Application No: AW/228/21/RES
Site Address: Rear of 34,36,38,40 & 44 Carlton Avenue Aldwick Bognor Regis PO21 3LR
Description of works: Approval of reserved matters following outline consent AW/130/18/OUT (layout, scale, landscape & appearance) for the erection of 8 No dwellings with access between 34 & 36 Carlton Avenue.

Thank you for your internet representation made on 20th July 2021 which has been recorded as an objection with the comments as follows:

SWEPT PATH ANALYSIS USING A
DB32 FIRE APPLIANCE

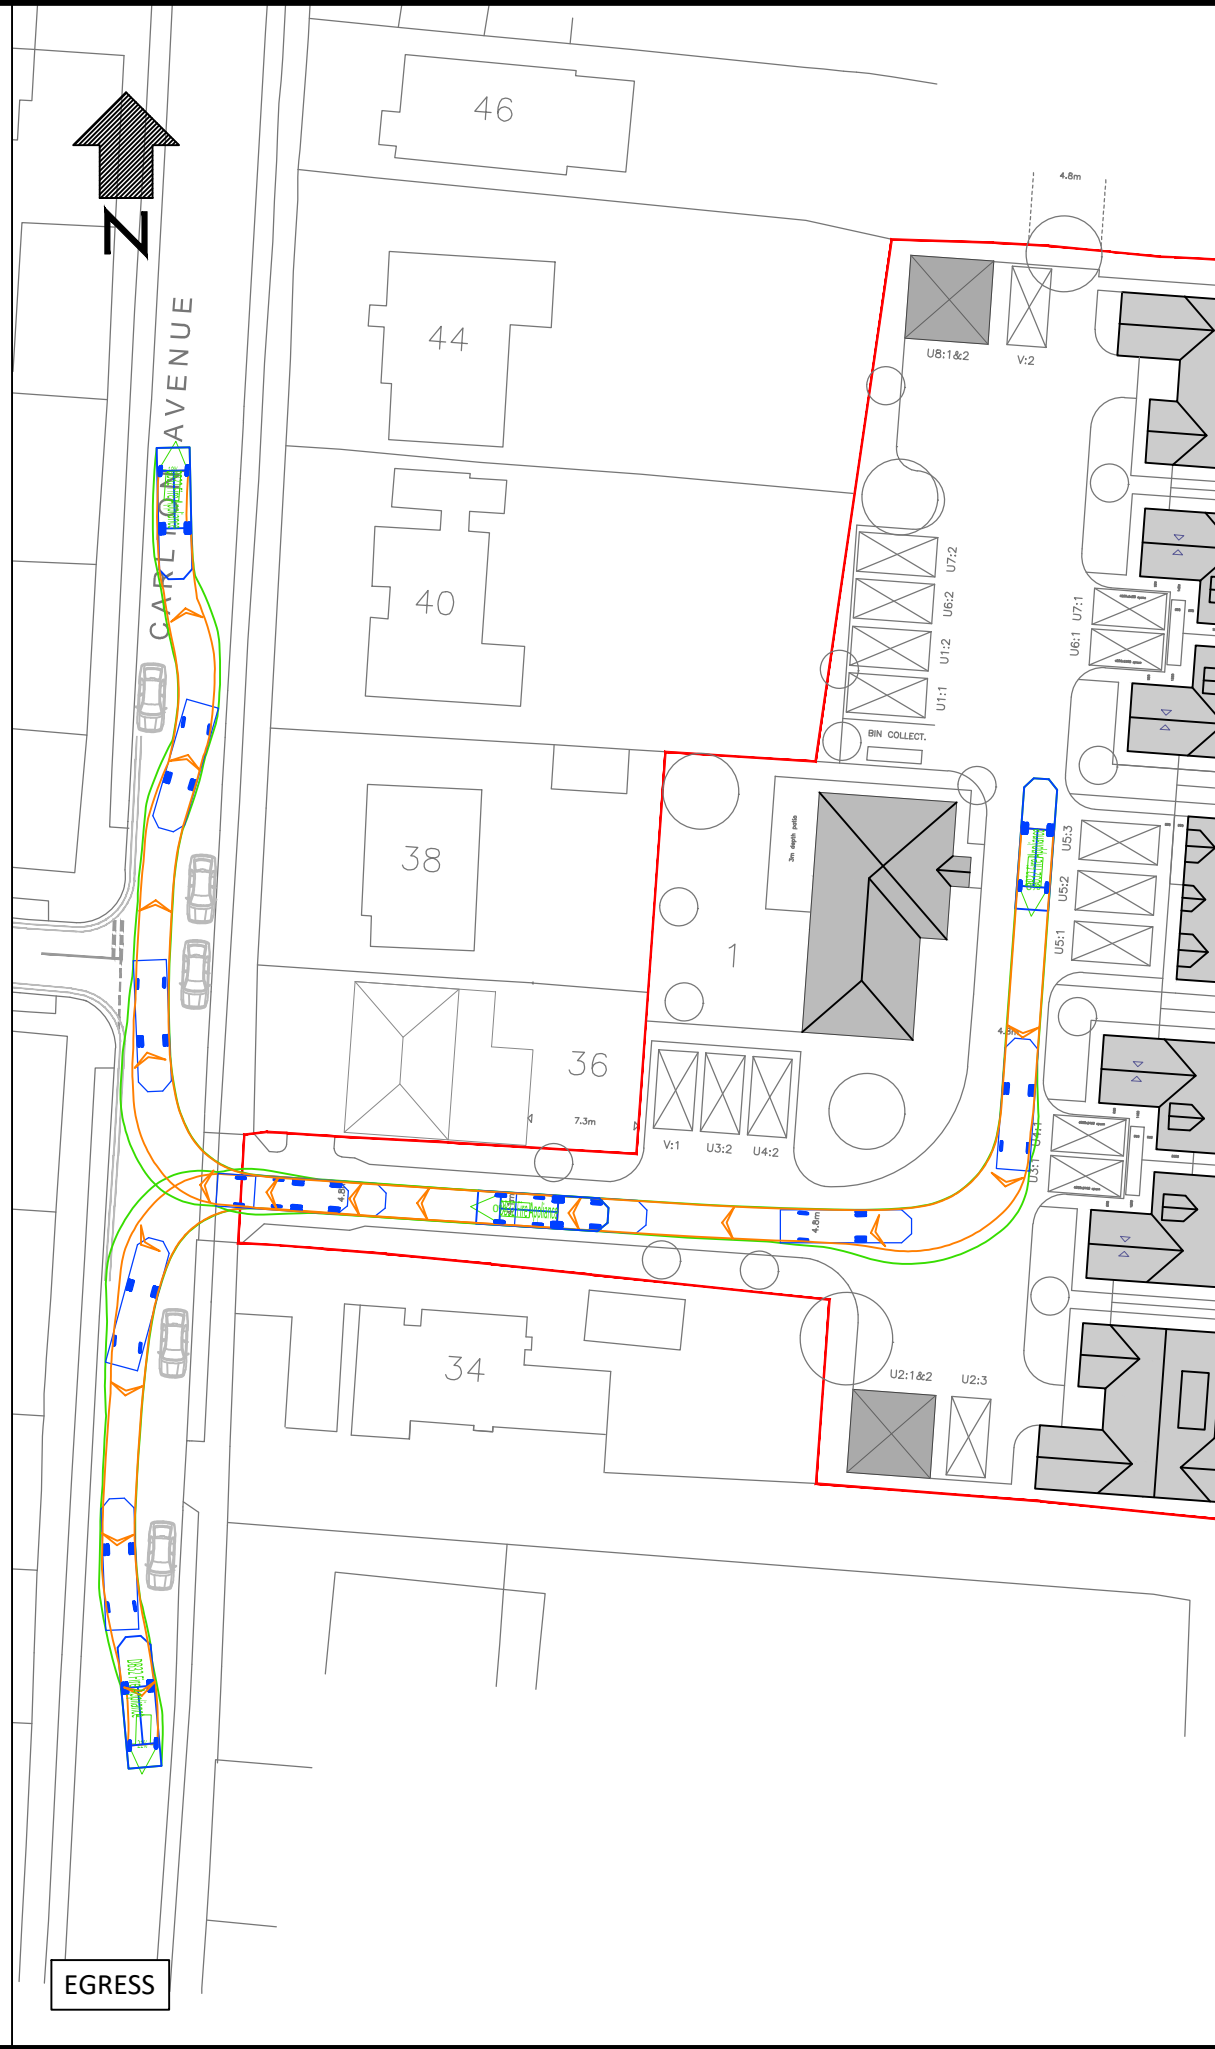
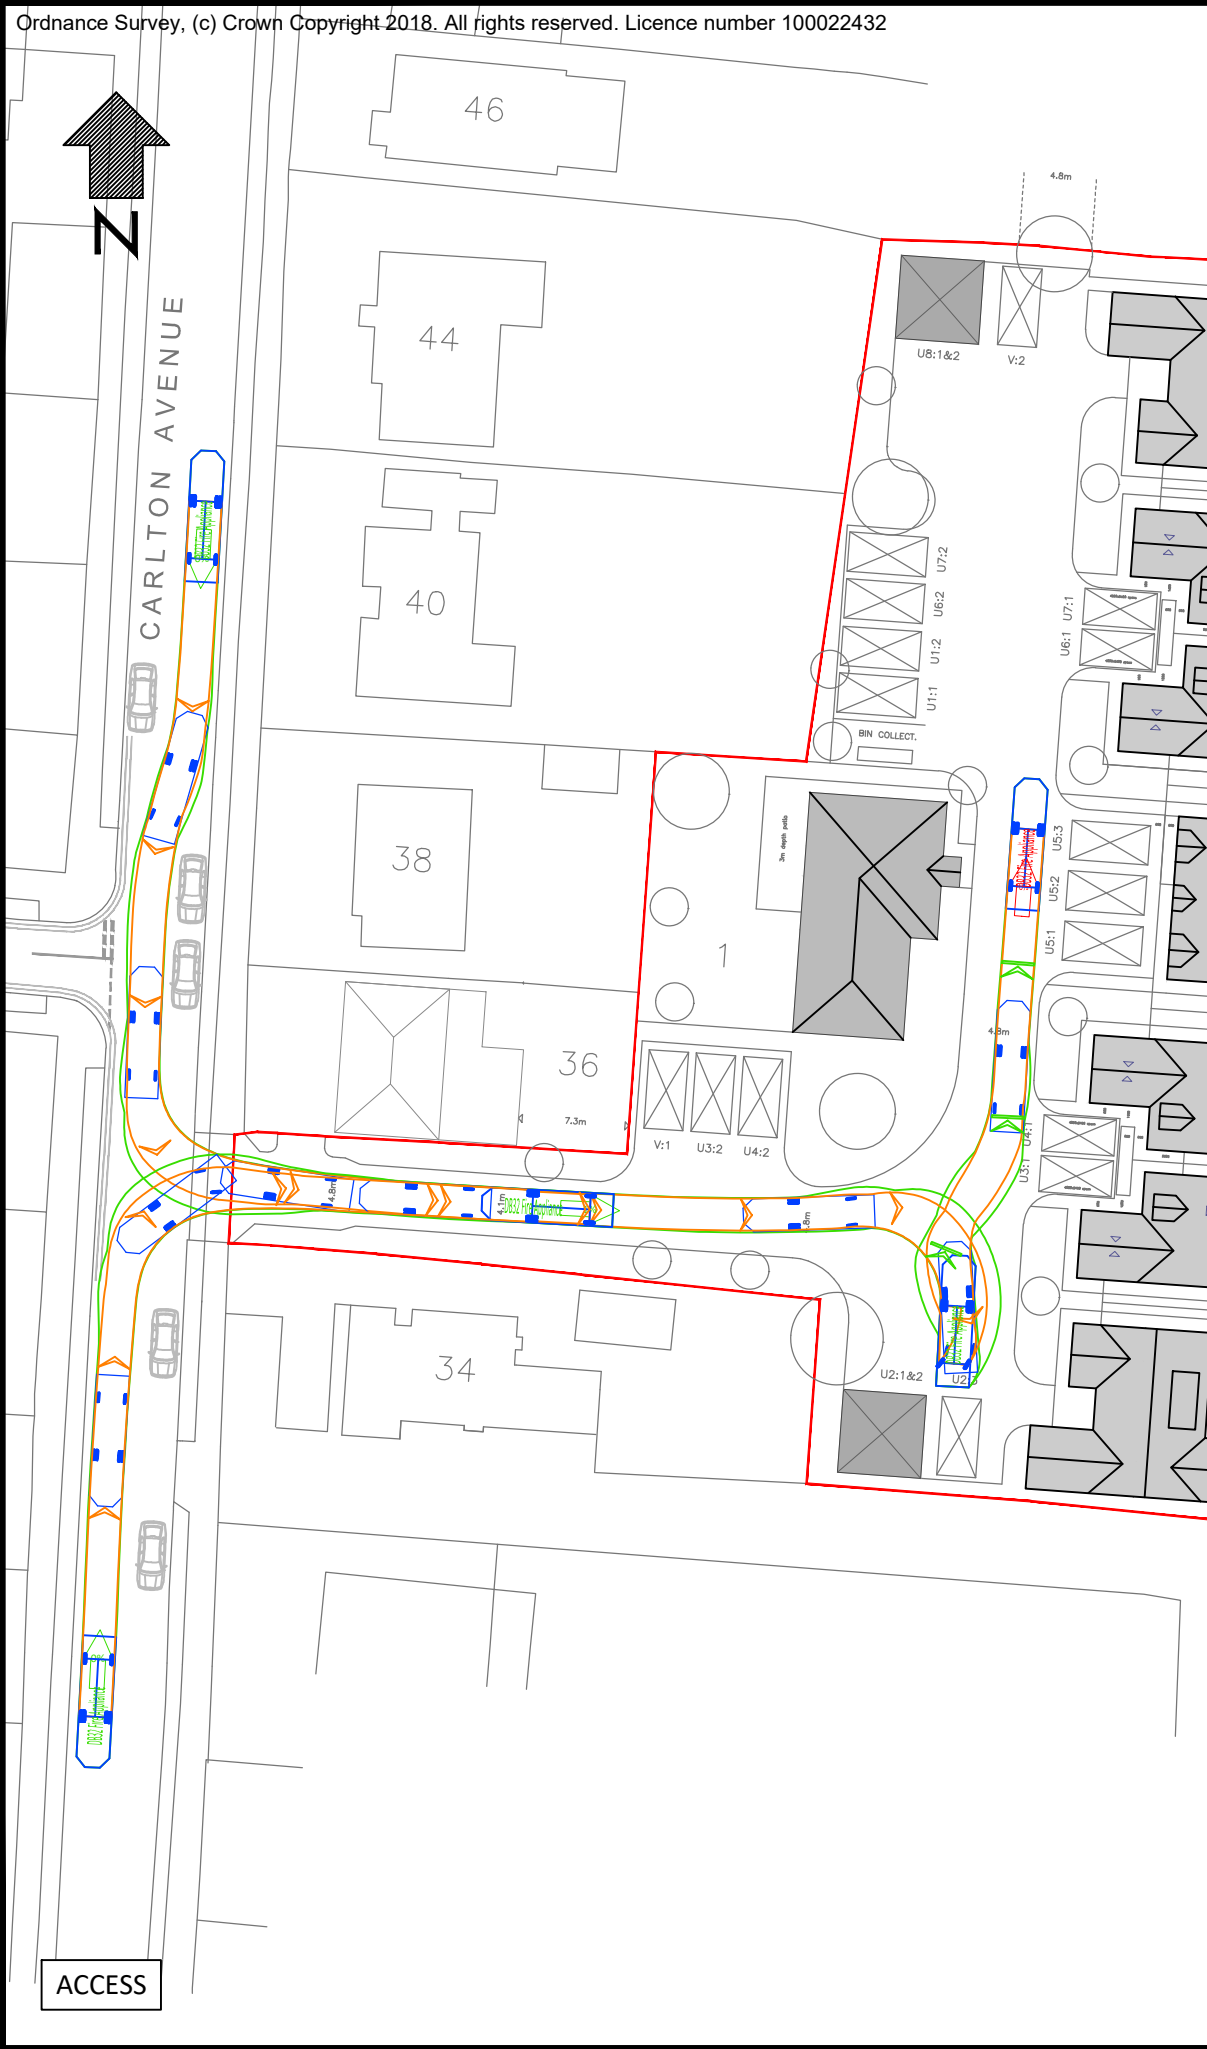
Members strongly objected to the application on the grounds that the proposed internal access road represents a danger to school-children attending the local school and to residents. Members did not consider that the road provided a convenient or safe route for pedestrians or cycles. Therefore Members agreed that the application is in direct conflict with Policy TDM1 of the Arun Local Plan 2011-2031 and with the Parish Design Statement (Page 48).
